CITY OF ALBUQUERQUE

**RE: Snow Vista Self Storage
Conceptual Grading and Drainage Plan
Engineer's Stamp Date: 09/27/23
Hydrology File: M09D012B**

TIERRA WEST, LLC

**RE: 98TH & SAGE STORAGE
CONCEPTUAL GRADING AND DRAINAGE PLAN
RESPONSE TO COMMENT**

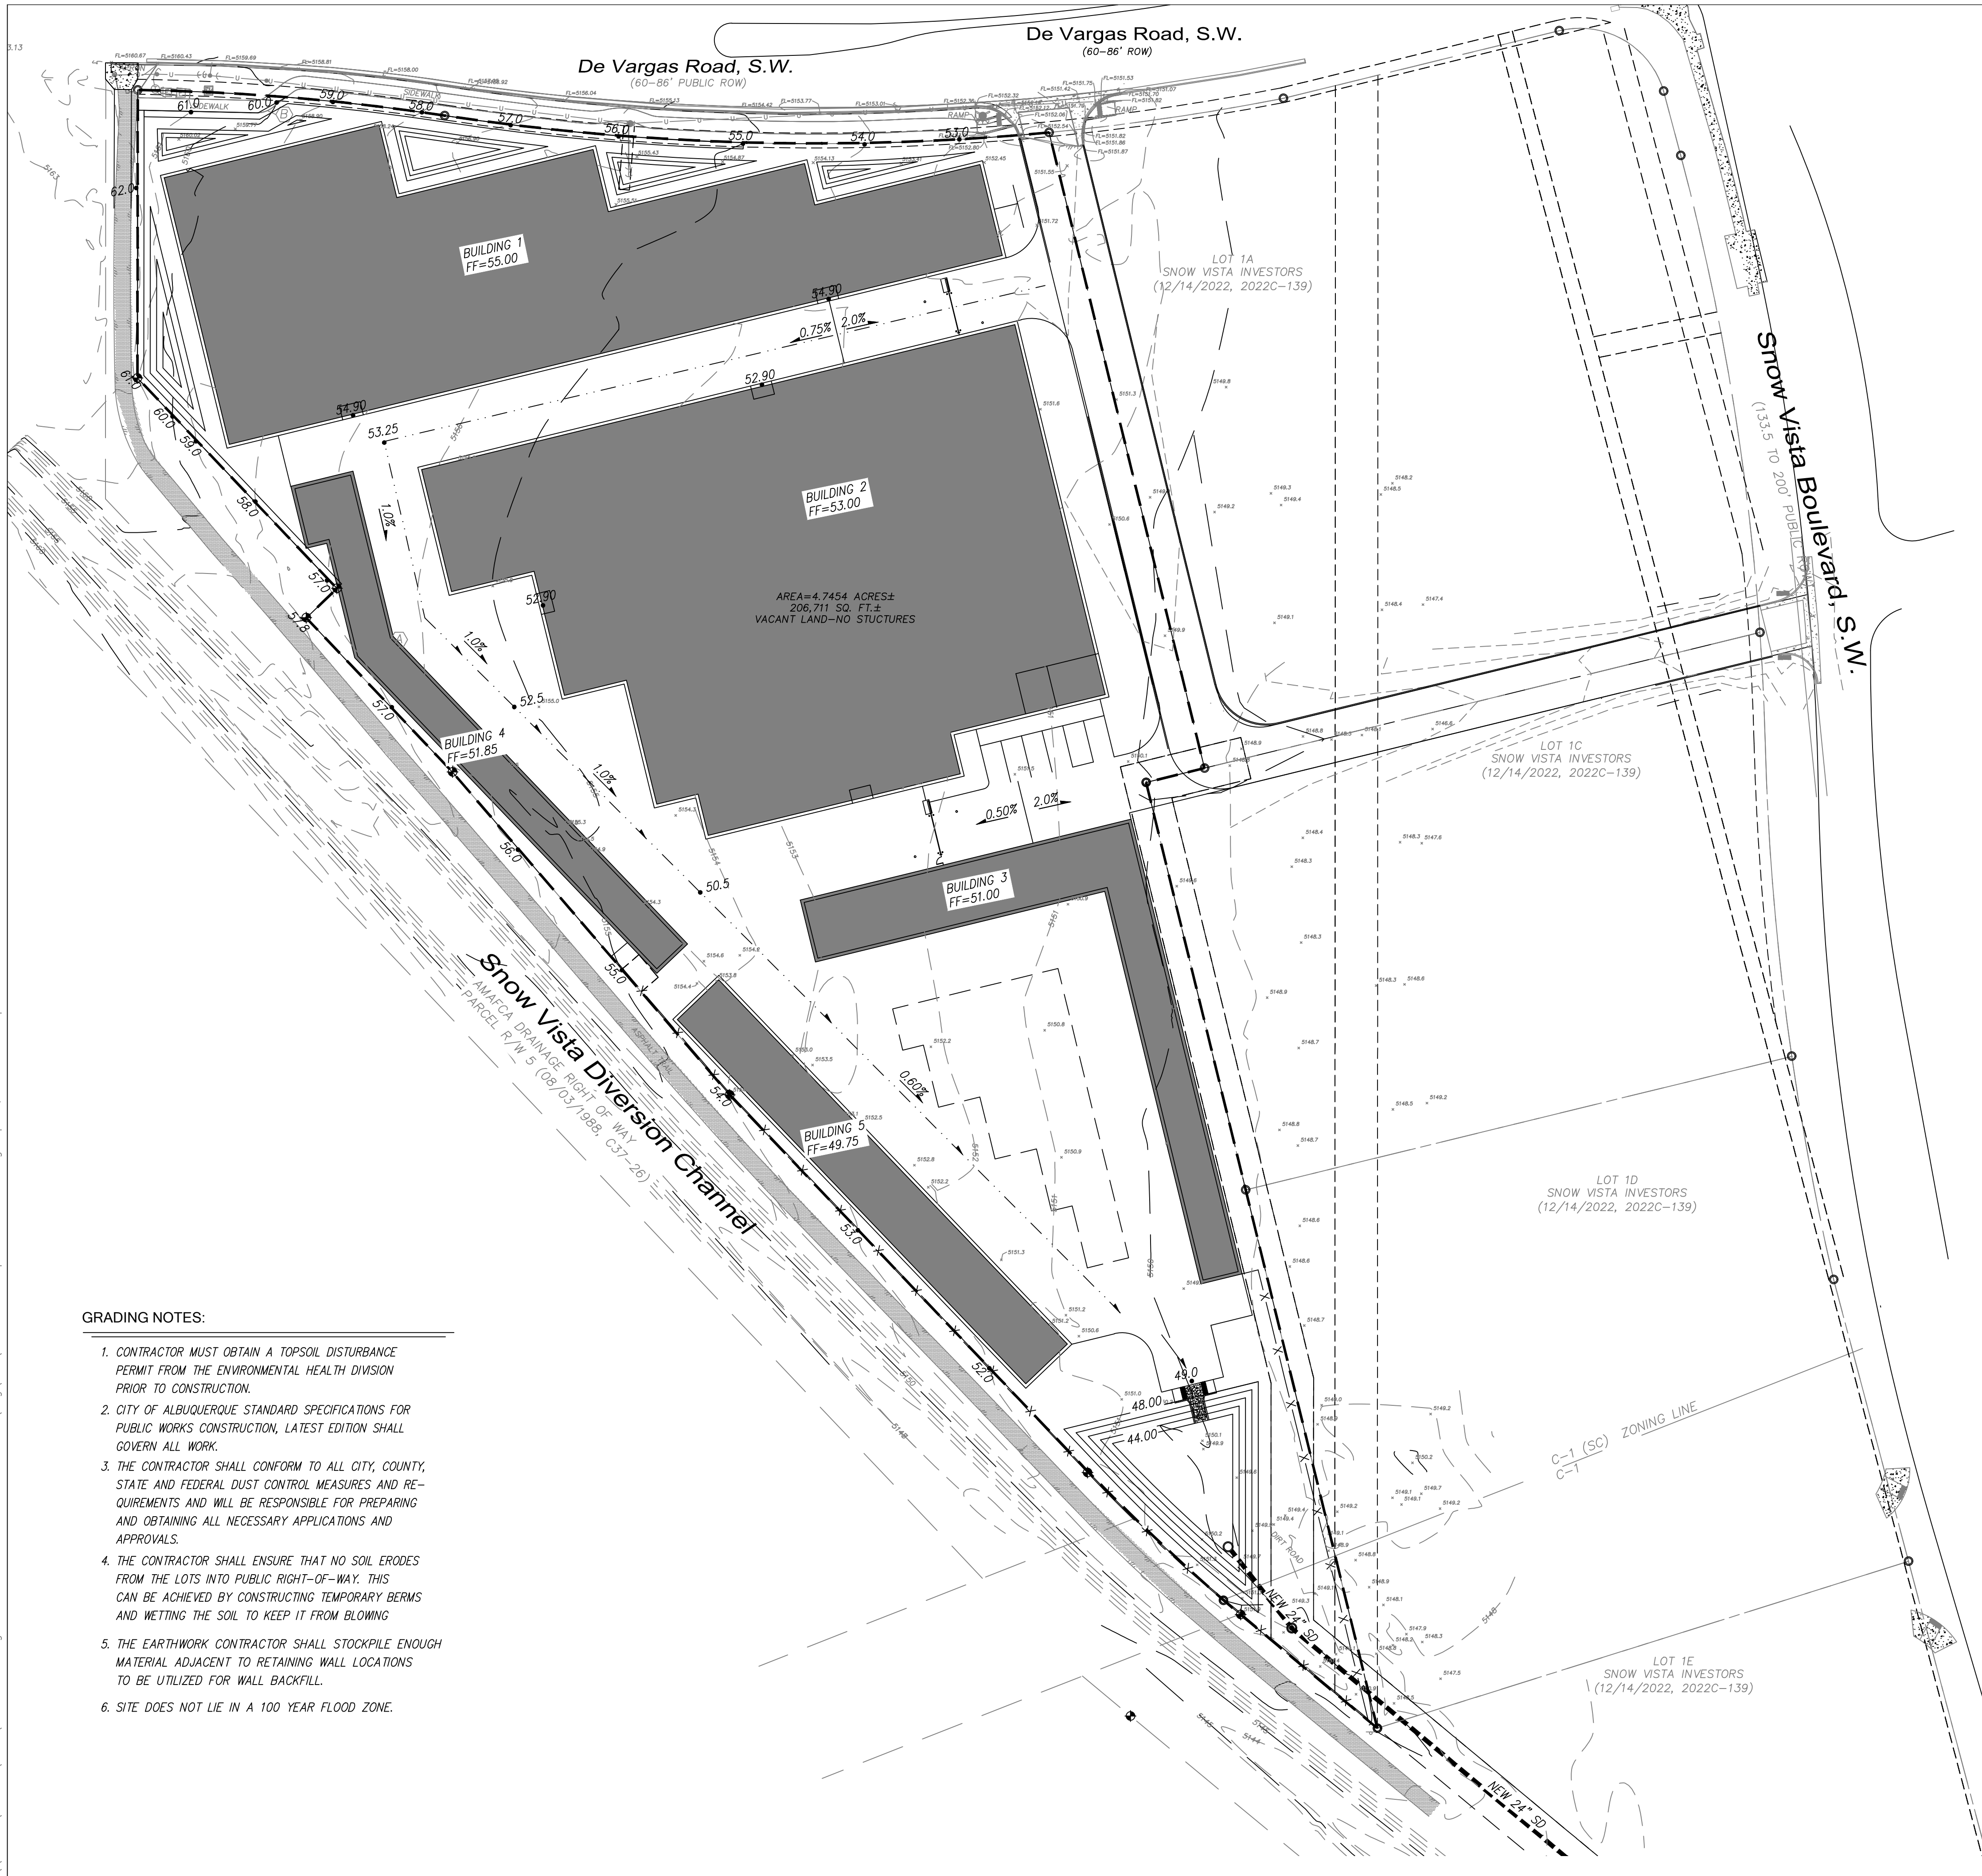
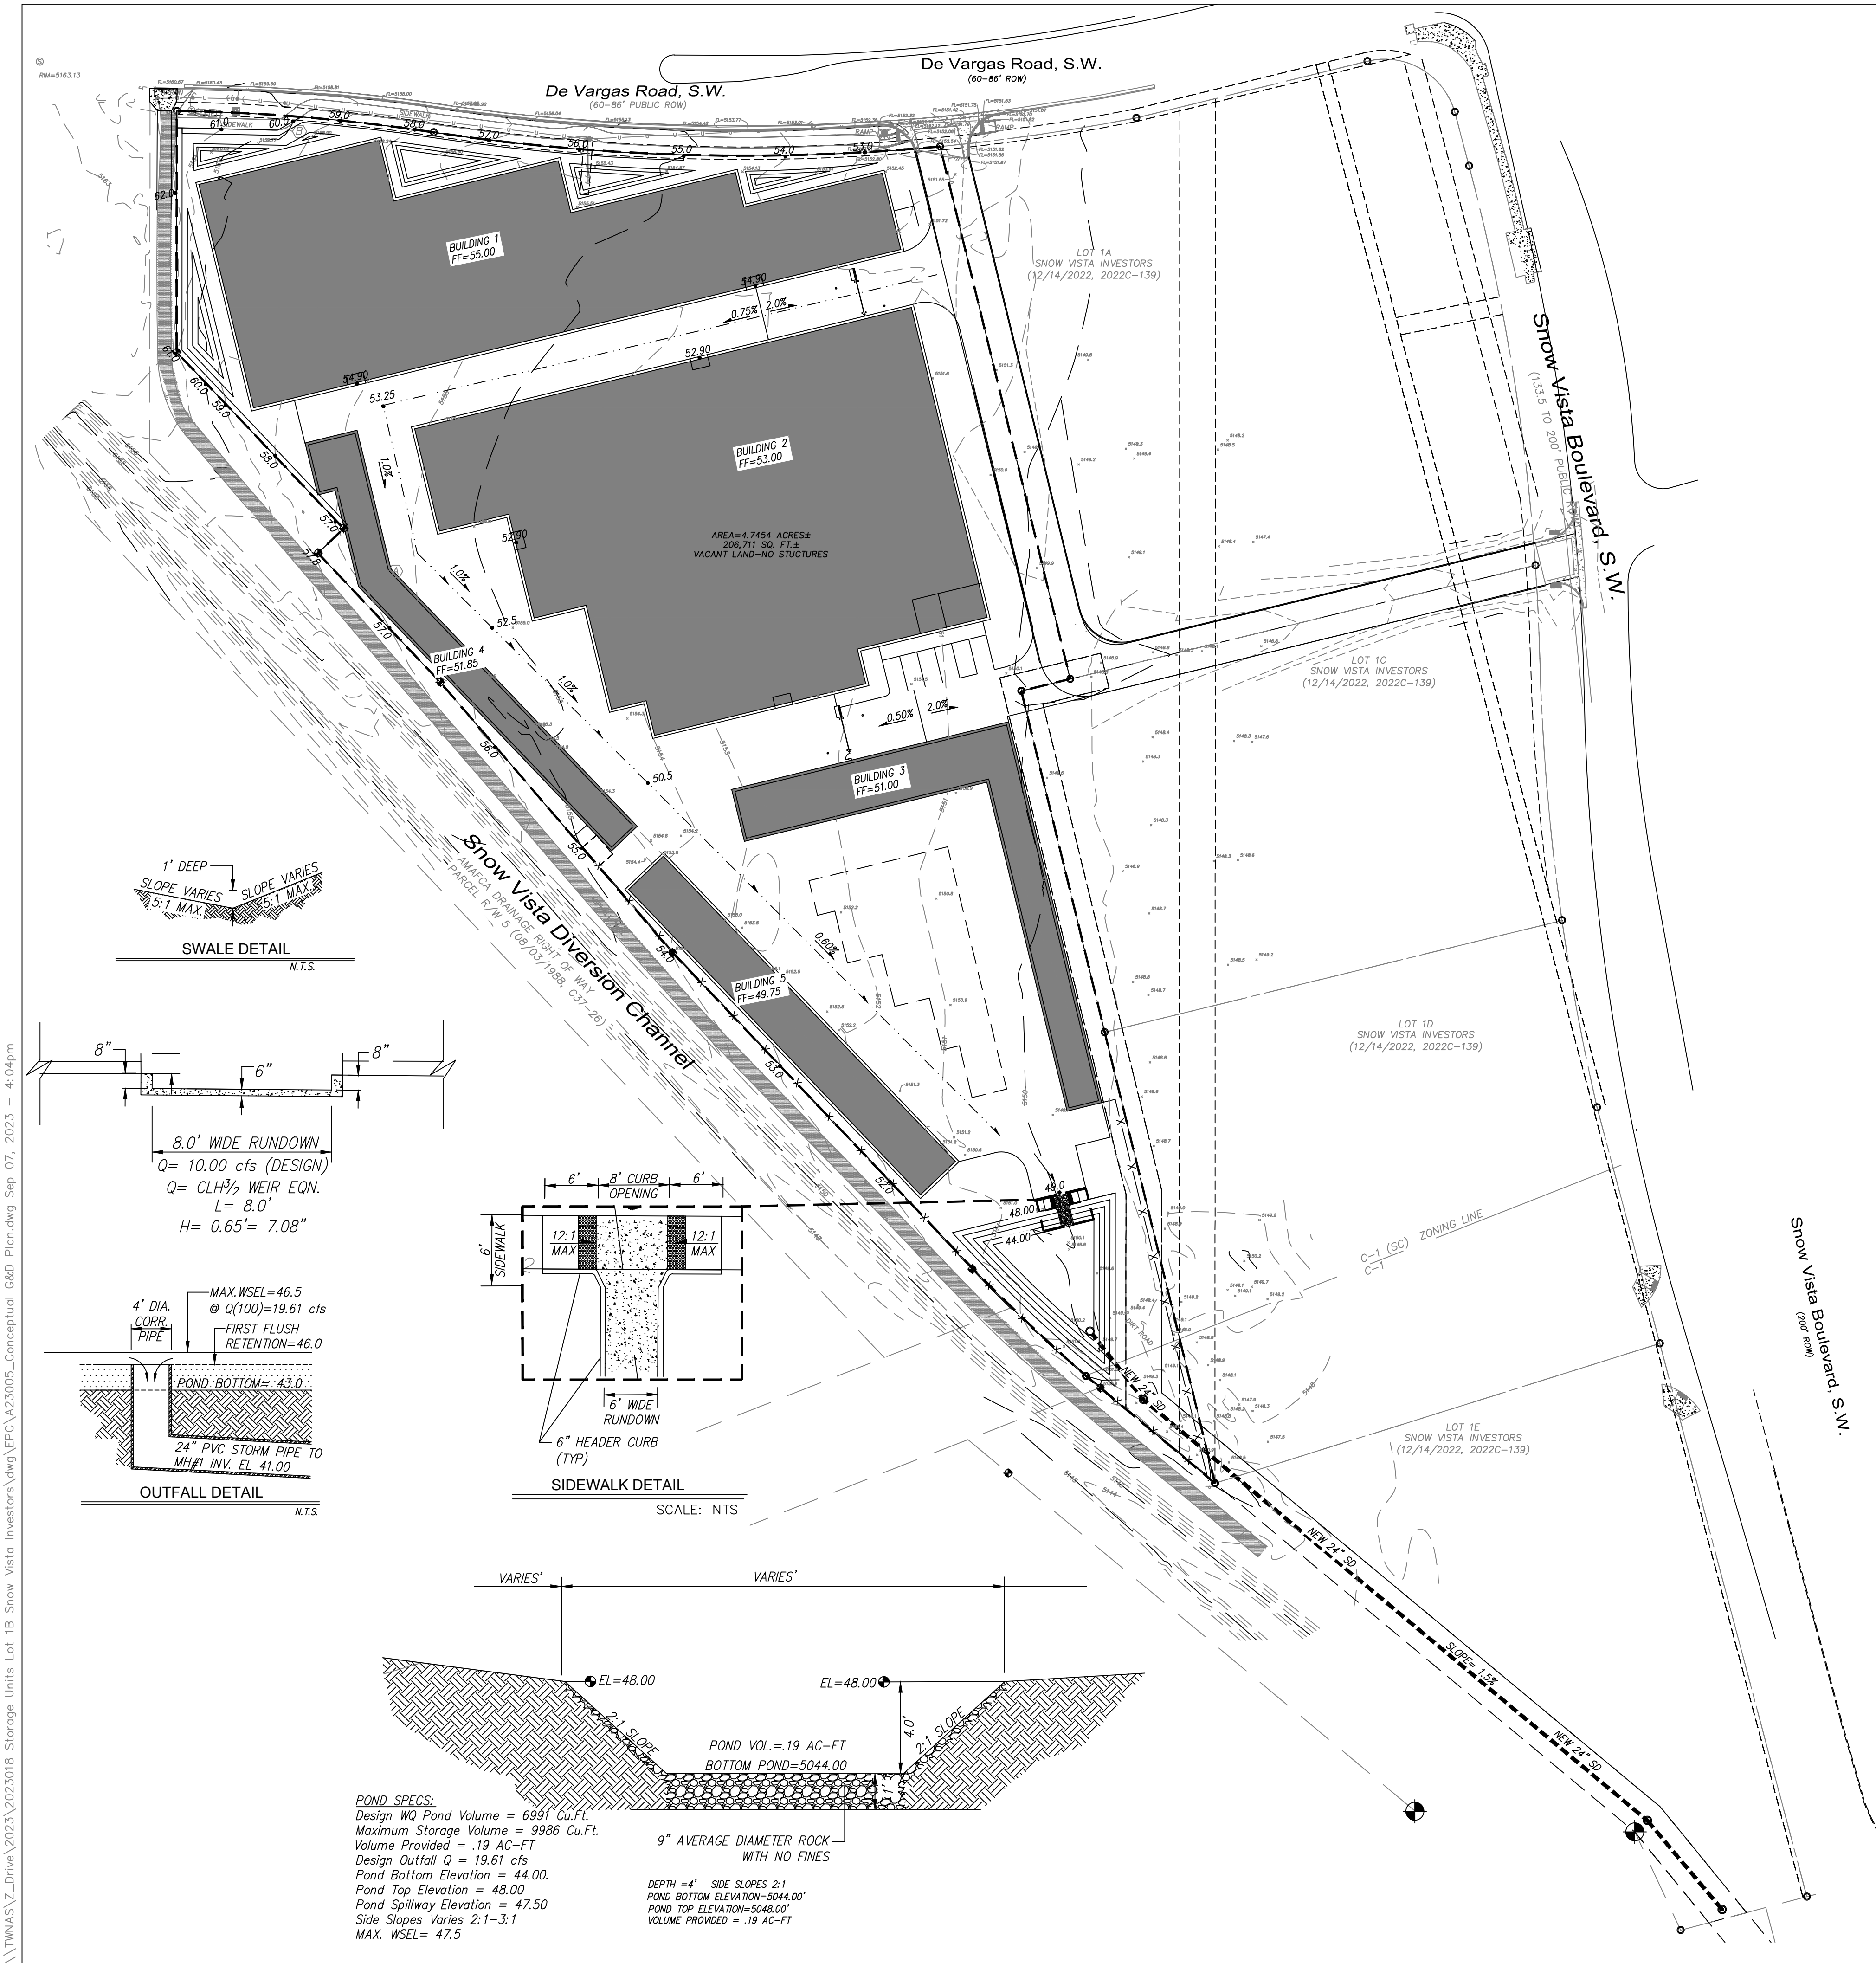
1. Please remove all the stormwater quality ponds around Building 1. All of these are on the High side of the development and will not capture any stormwater. Please make sure that the southeast pond is.

Response: Storm water quality ponds around Building 1 have been removed. Southeast pond is sized to contain the water quality volume.
2. Please show the storm pipe that was approved for the overall development on July 20, 2023. Please label as "Overall Developer to construct prior to any further Building Permit approvals for the lots within the development."

Response: Storm drain added and noted as directed.
3. Please either consolidate the drainage calculations and the details to GR-2 and rename to GR-1 or change the scale on GR-1 to 1"-40'.

Response: Changed scale on GR-1.
4. Please change the Title of the sheet to "Conceptual Grading and Drainage Plan."
Response: See updated GR-1 plan.
5. Please add the note, "Not for Construction."

Response: See updated GR-1 plan.
